During the detail design process, it has become necessary to review aspects of the approved Planning scheme to resolve the requirements of the environmental design, in order to create optimal learning environment, as well as taking on board the recommendations of the Designing Out Crime Officer. The required changes are described below.

### Daylighting

PROJECT	HARPLEY SCHOOL		
	Tollet Street, E1 4EE		
DRAWING TITLE	GA ELEVATION		
	SHEET 03		
DATE	FEB 21	DRAWN	CS
SCALE	1 : 50	@ A1	CHECK
STATUS	PRELIMINARY		
RT JOB NO.	RT20087	REVISION	PR02
DRAWING NO.	HS-RTA-XX-XX-DR-A-00703

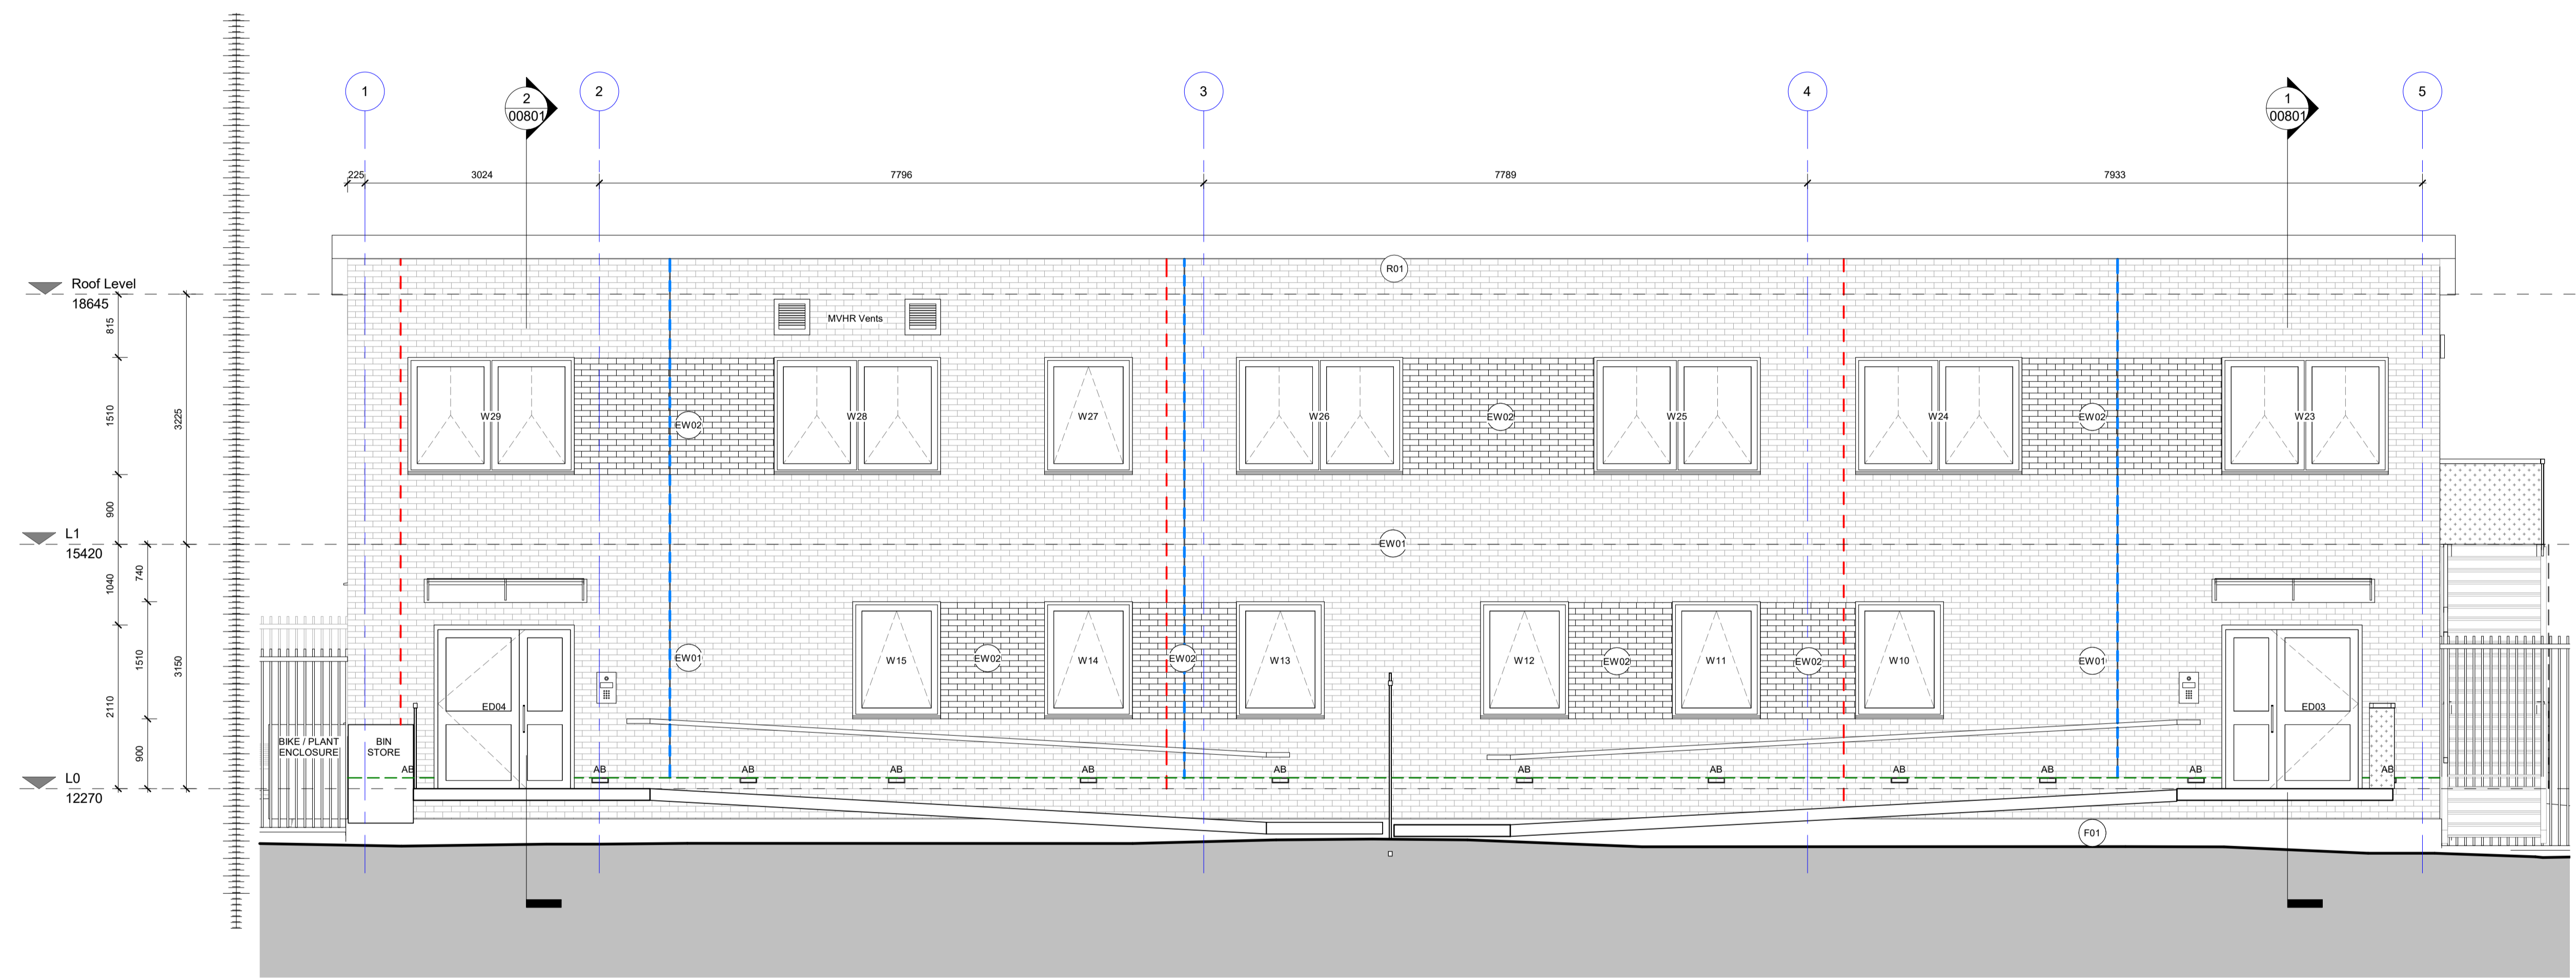
As such, we have proposed to split the large windows into two smaller windows which are more evenly spaced within the room. The example shown below, demonstrates a pass under both criteria. Further details are provided with the accompanying daylighting report.

As a result of changes to the internal layout – following a strategic review by the Head Teacher – the placement of rooms at first floor is broken by the presence of a small office in the middle. The addition of a dedicated window improves the internal environment and also have a positive impact on the balance of the elevation. One external door at Ground Floor has also been replaced by a window.

To achieve the same design principles as the original scheme, we have connected each pair of windows by special brickwork - whereas previously there were 3 large windows, all connected together. We feel this achieves the same design aesthetic, but with the significant benefit of improving the teaching environment for the school's students.

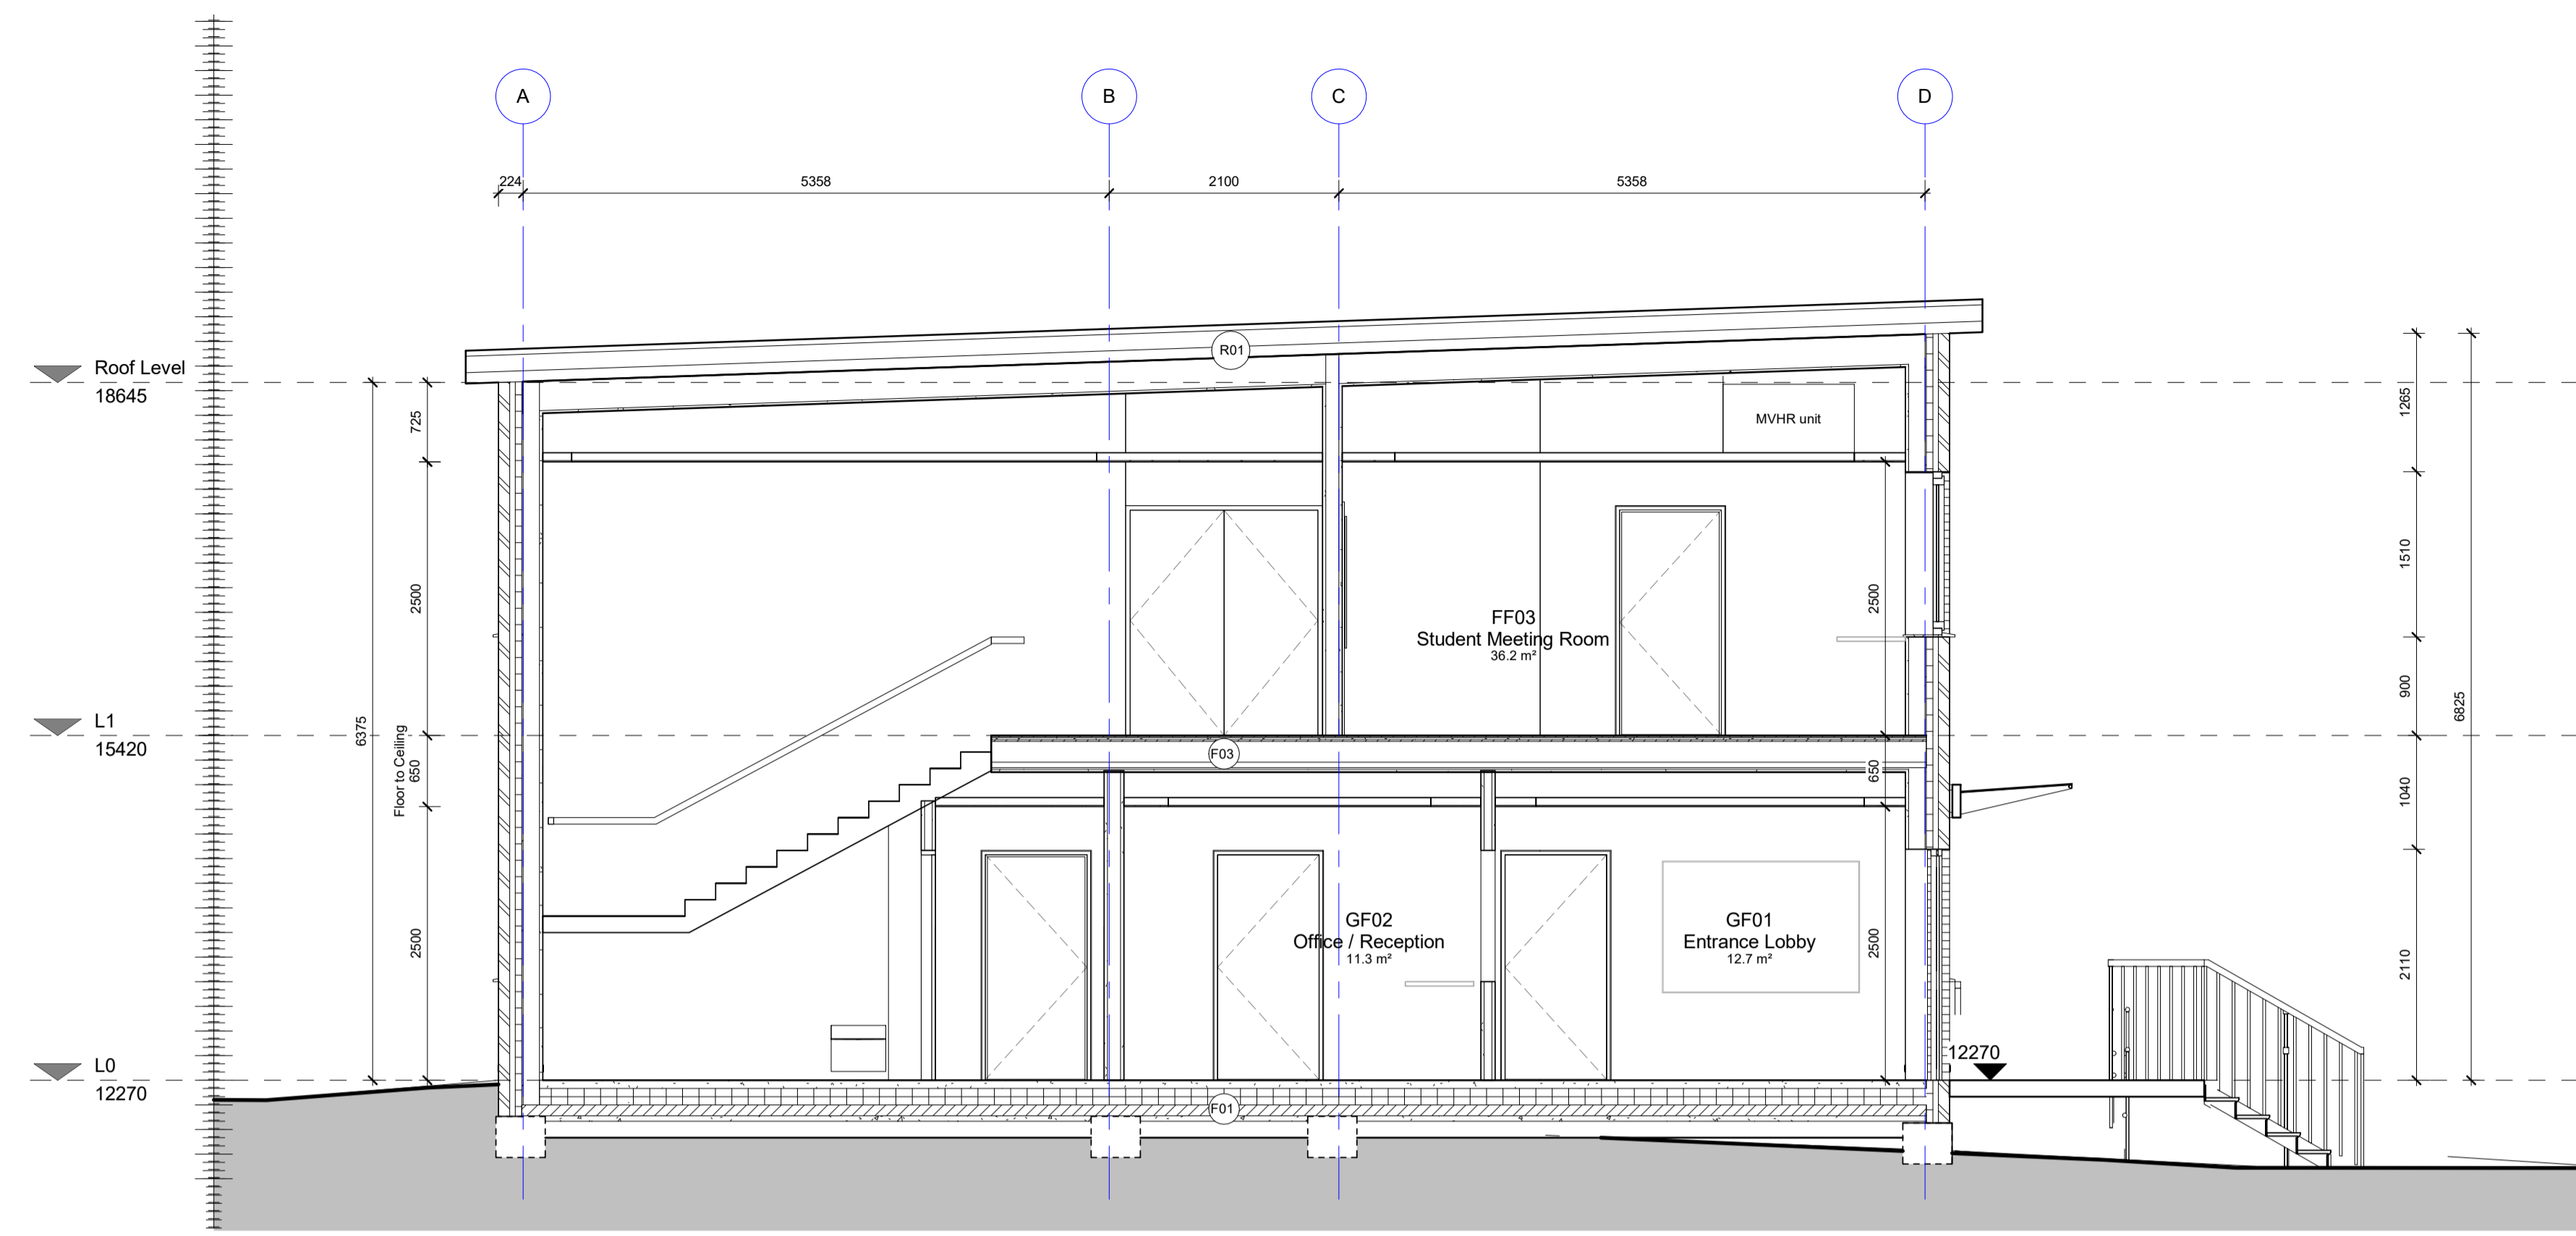
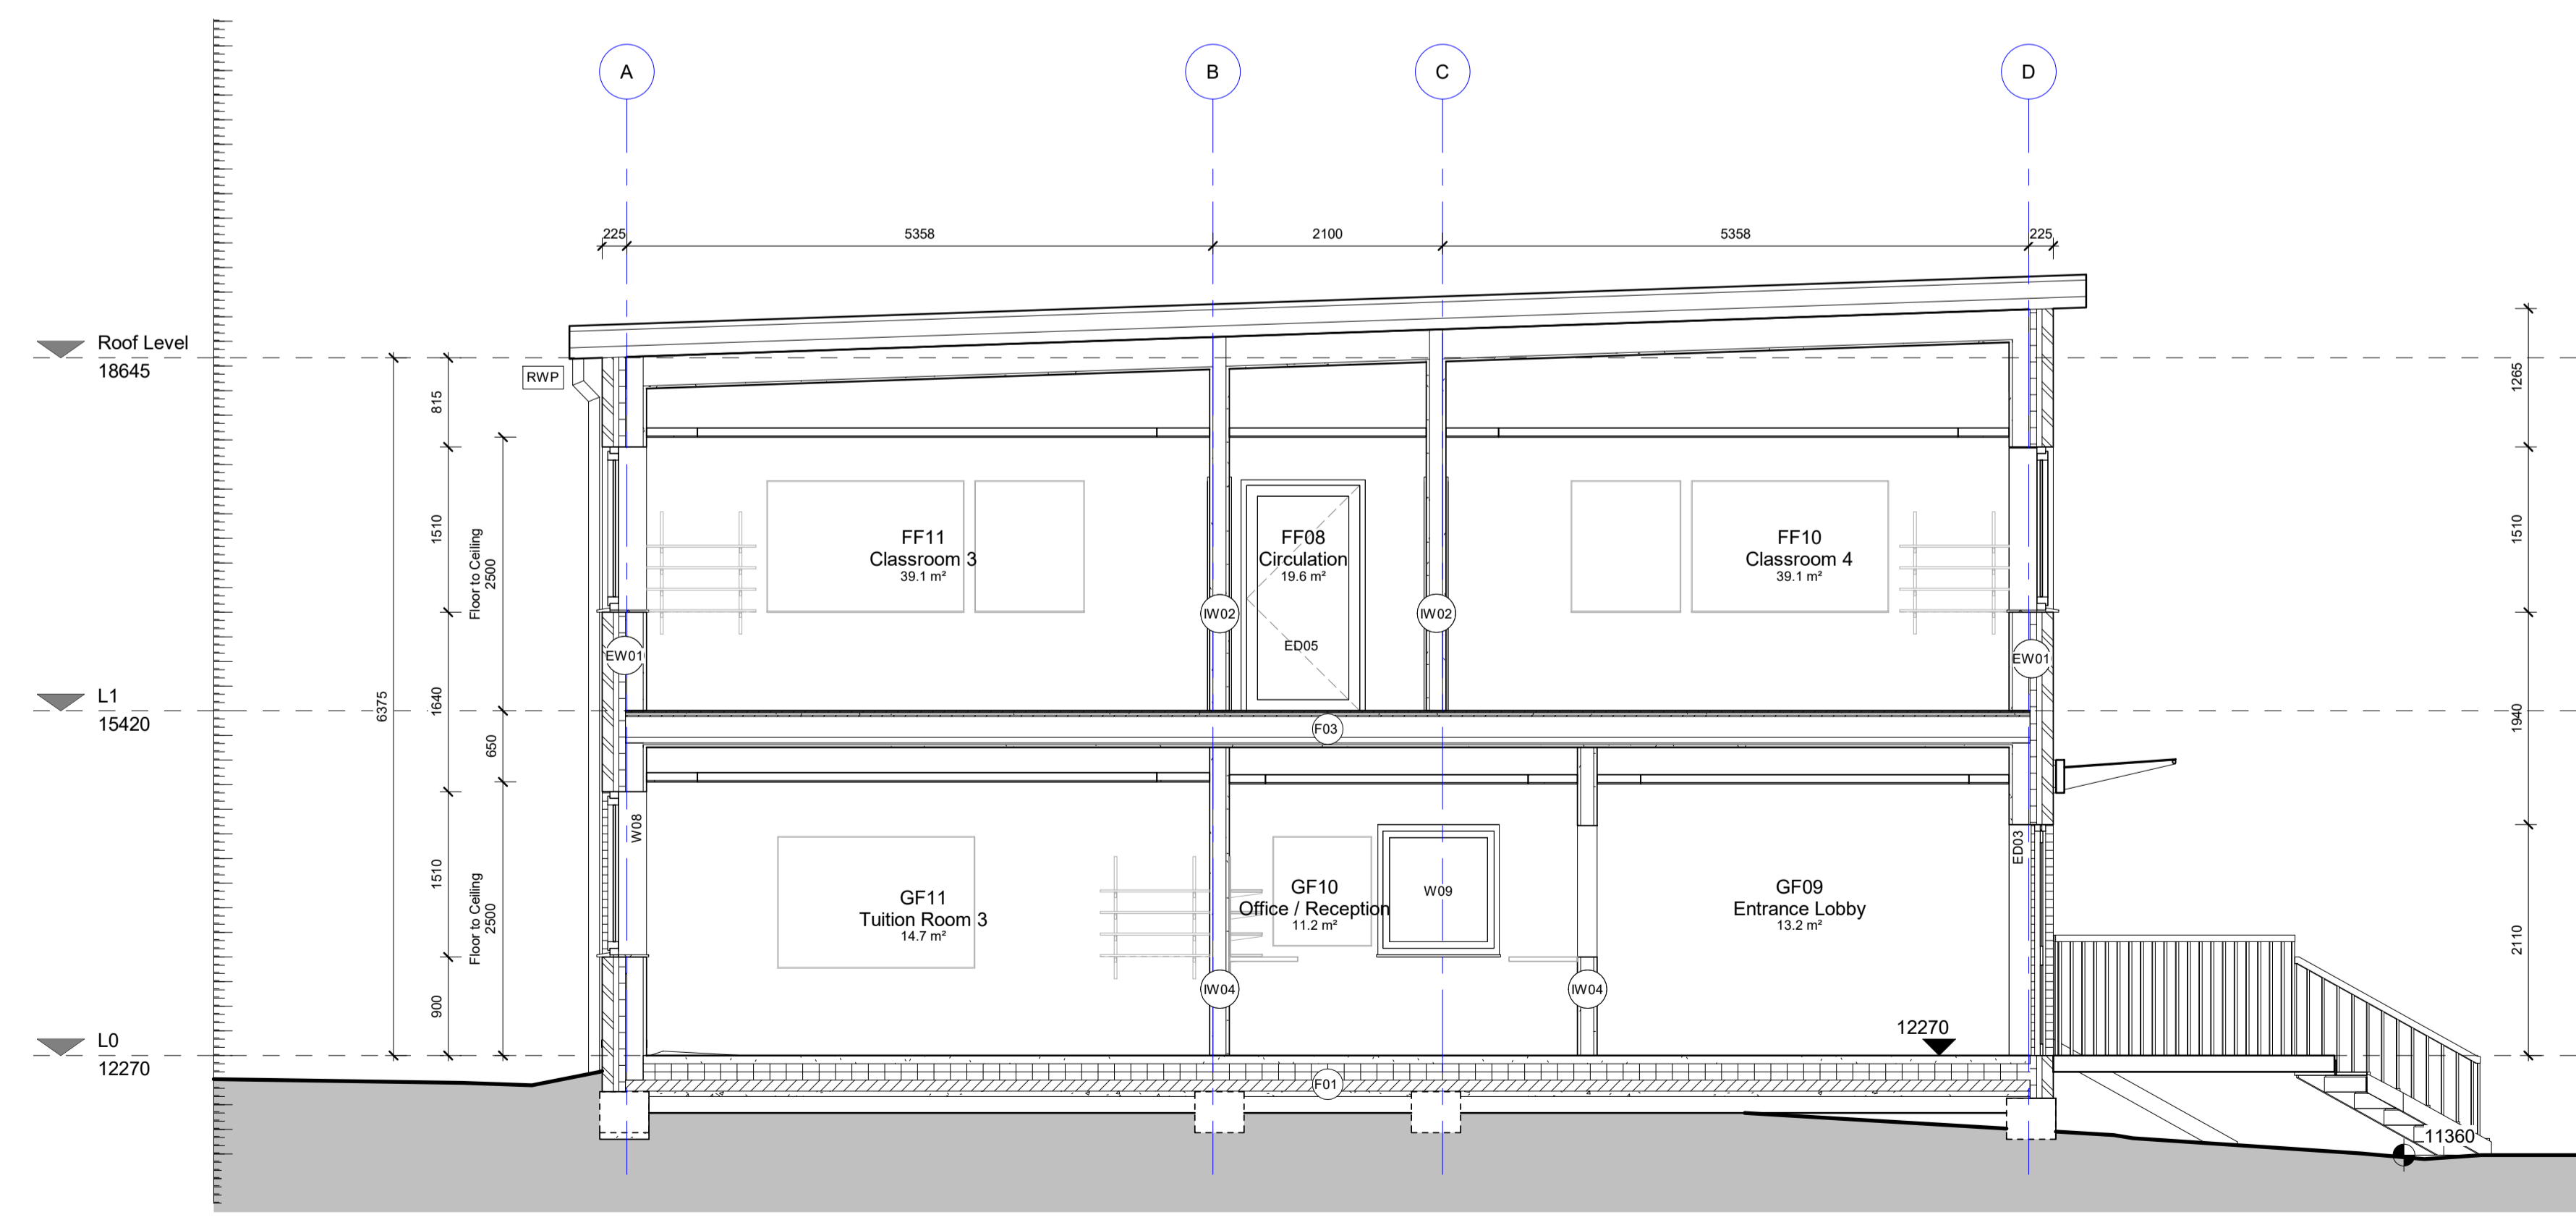
Despite the need to increase window sizes to improve daylighting, the acoustic assessment of the existing site confirmed that the surrounding environment is too noisy for the windows to be used for ventilation. As a result, Mechanical Ventilation with Heat Recovery or Hybrid Ventilation is required in order to provide adequate ventilation, while also keeping noise levels to a minimum.

The slope of the existing site means the building needs to be raised on a plinth with stepped/ramped access. To minimise the impact on the street, the original design utilised 2.5m internal ceiling heights and minimal ceiling void – the minimum recommended ceiling height for classrooms is 2.7m.

These ventilation units are sizable and required to be located within the ceiling void, which subsequently has to increase to provide sufficient space. As the ceiling heights are already lower than recommended, there we are unable to reduce them further, and it has become necessary to raise the overall height of the building to accommodate the MVHR units. By changing from a curve roof to a mono-pitched roof, we are able to minimise the overall increase in building height.
